The White Rock Wind Farm proposal is for the development of a medium sized wind farm in the Northern Tablelands region of NSW, 20 km west of Glen Innes and around 500 km north of Sydney.

1.1 Purpose of this Report

The Department of Planning provided copies of the submissions from members of the public and government agencies and asked the proponent to respond to the issues in accordance with Section 75H of the NSW Environmental and Planning Assessment Act 1979. This Submissions Report considers and responds to the issues raised in the submissions on the White Rock Wind Farm Environmental Assessment.

Figure 9-5 Photomontage Locations

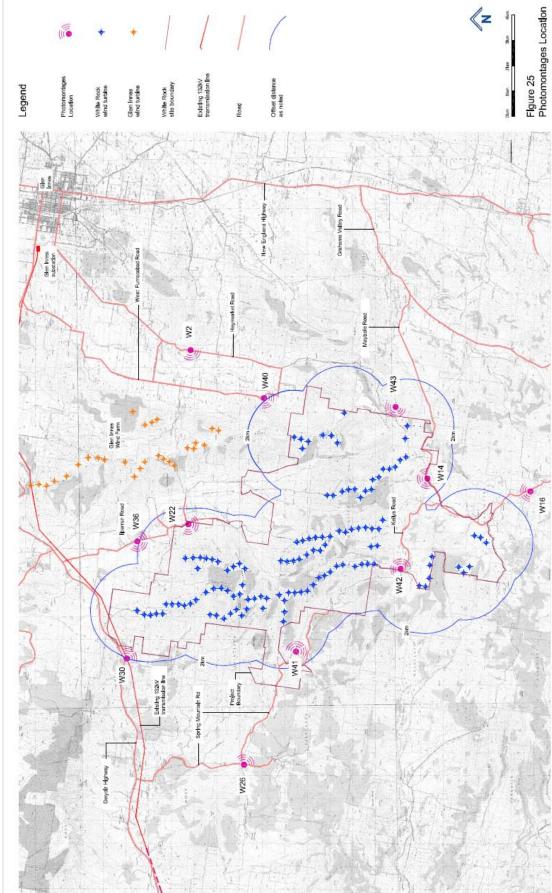
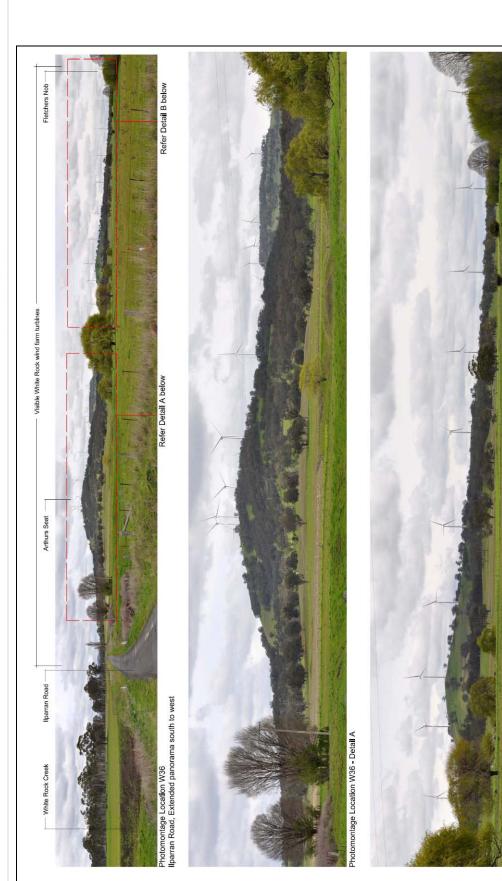
Accuracy of Figure 34 (Photomontage W41)	The photomontage locations used in the Landscape and Visual Impact Assessment (LVIA) were carefully selected by a Registered Landscape Architect experienced in the preparation of LVIA for wind farm projects. The "Tryagain" residence is surrounded by scattered tree cover, including trees to the north and east of the residence which partially screen the views towards the wind turbines within the wind farm – refer photograph below.
	"Tryagain" residence (left) and W41 camera location to the east (right)
	The selected location for photomontage W41 is on the wind farm side of a line of trees around 55m south east of the residential dwelling and was chosen to represent a typical view toward the greater number of wind turbines within the proximity of the residential dwelling. Epuron believes that the W41 photomontage (illustrated in Figure 34 of the LVIA included in the EA) provides an accurate representation of the view towards the wind farm from the residential curtilage.

Council's assessment and determination that turbine numbers 32 and 33 would be completely visible from the "Tryagain" residence, including blades, hub and entire tower is <u>not</u> correct. Cross sections (Attachment 4 of this report) from the "Tryagain" residence to turbine numbers 32 and 33 have been prepared in order to illustrate the likely extent of visibility. The cross sections demonstrate that the lower portions of the towers and blades will be screened by tree cover on land rising to the north east above the "Tryagain" residence toward the wind farm. Whilst the hubs and portions of the blades will be visible, turbines 32 and 33 are

not considered to have an over bearing visual dominance on the residence's views.
